**WEST SUSSEX COUNTY COUNCIL
STRATEGIC PLANNING CONSULTATION**

SUBJECT: R/58/15/DOC - Application for approval of matters reserved by condition imposed under R/294/14/PL relating to conditions 3&4 for schedule & samples of materials & vehicle parking details.

The Studio, Waverley Road, Rustington, BN16 2BZ

1516/01/11/E

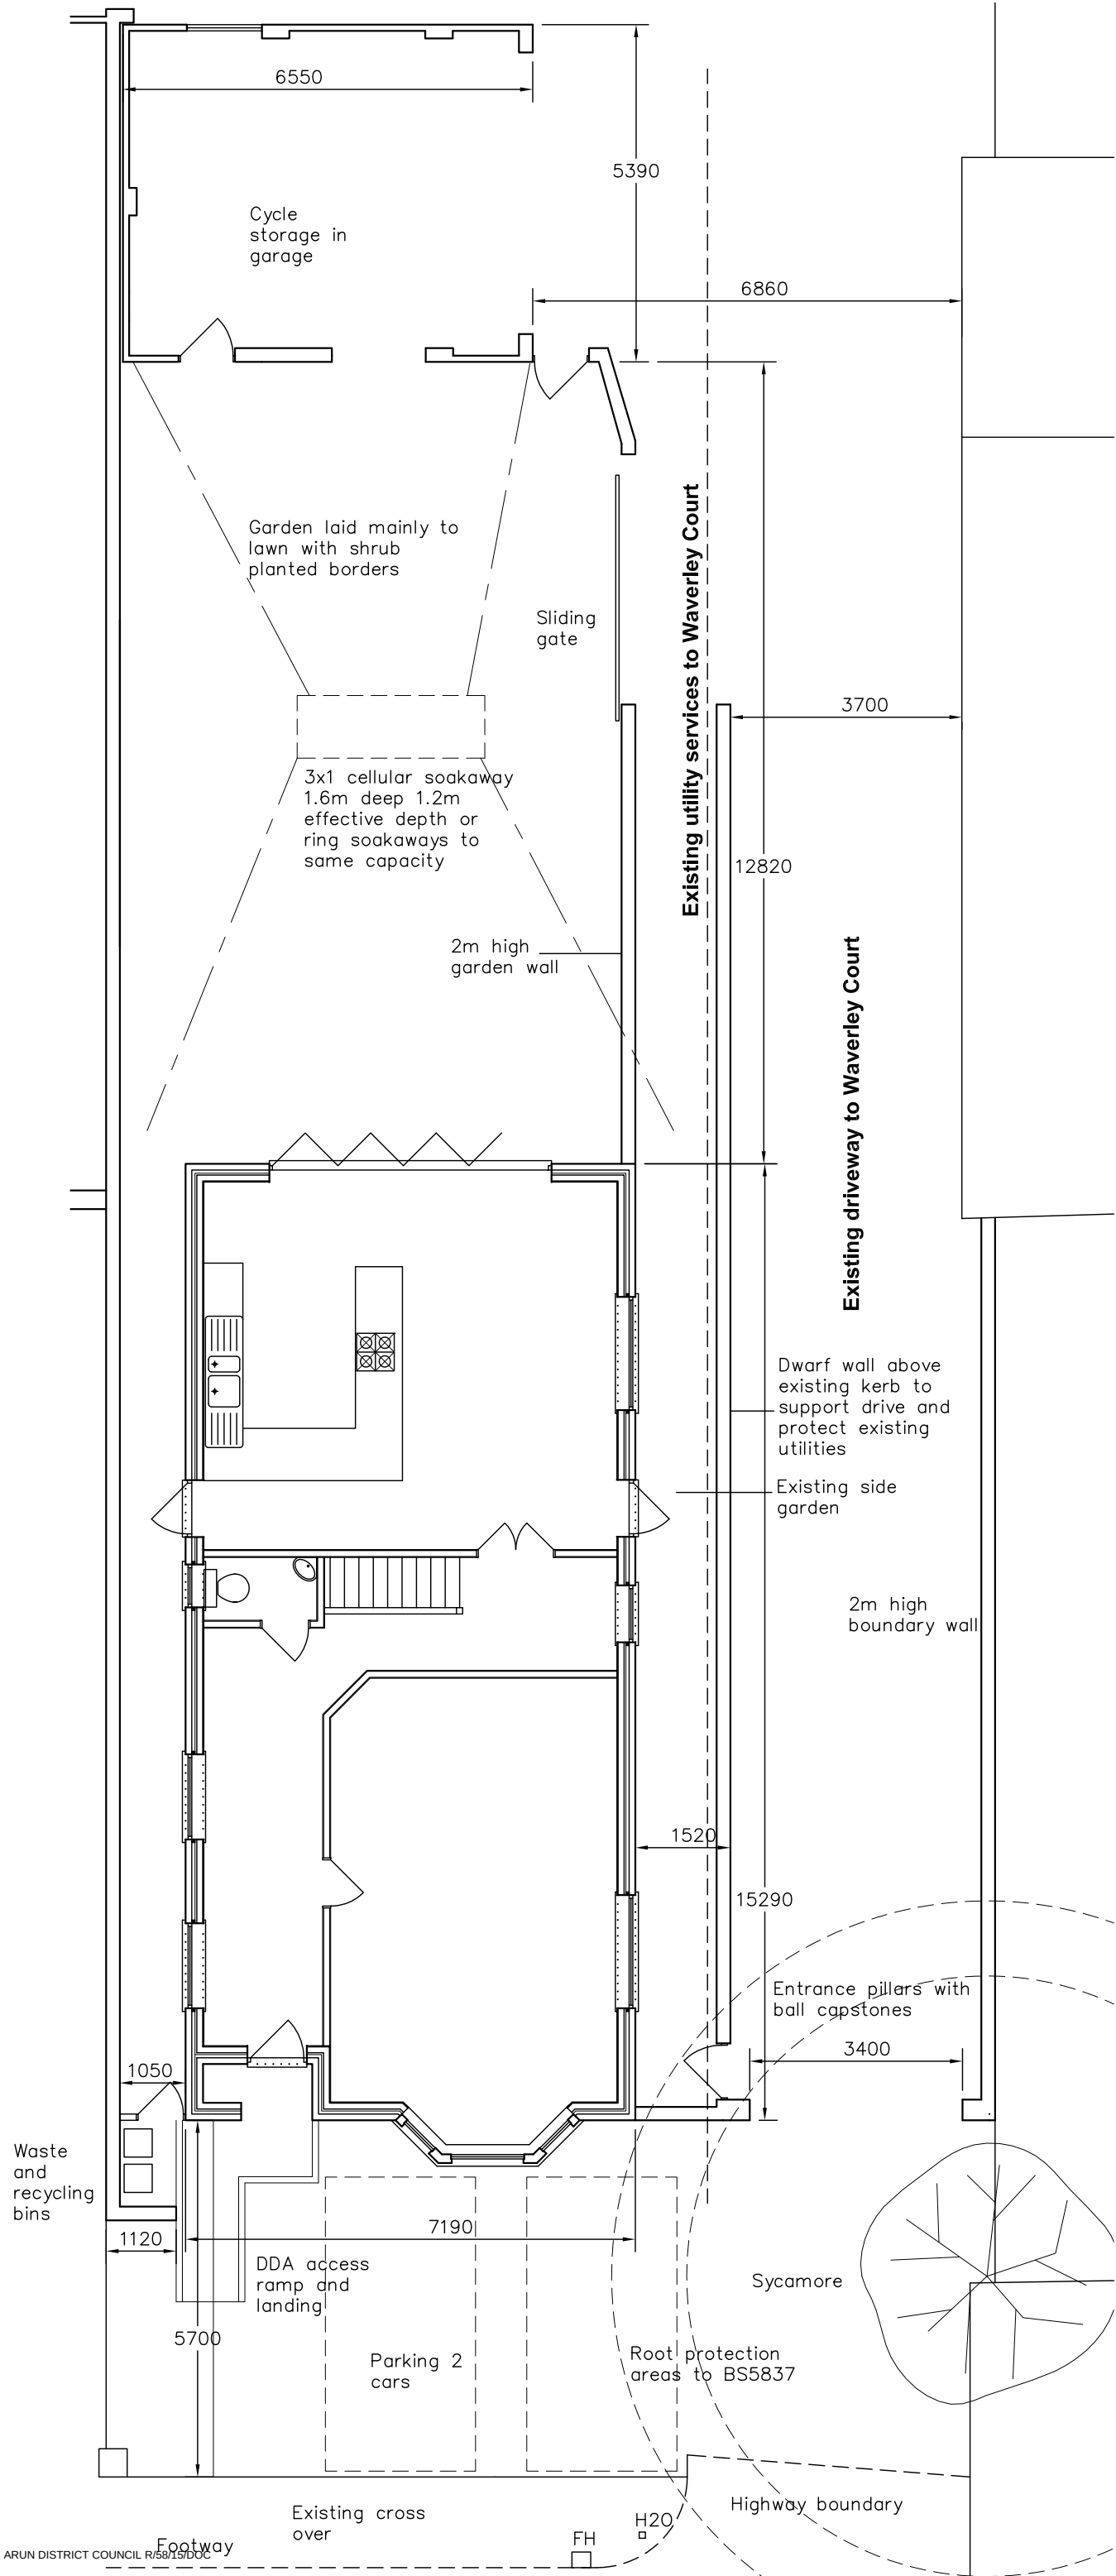
A plan has been provided (1516/01/11/E) which details vehicle parking within the proposed site frontage and proposed garages to the rear of the site. The principle of this provision was established within the original application (R/294/14) and would therefore be considered acceptable. I would note that WSCC would advise vehicle parking spaces measure 2.4 x 4.8 metres in size, the spaces on the site frontage are marked at 2.4 x 4.7 metres, though there is in practice a frontage of 4.9 metres that can be used.

No concerns would be raised to the plans and details provided in relation to this condition
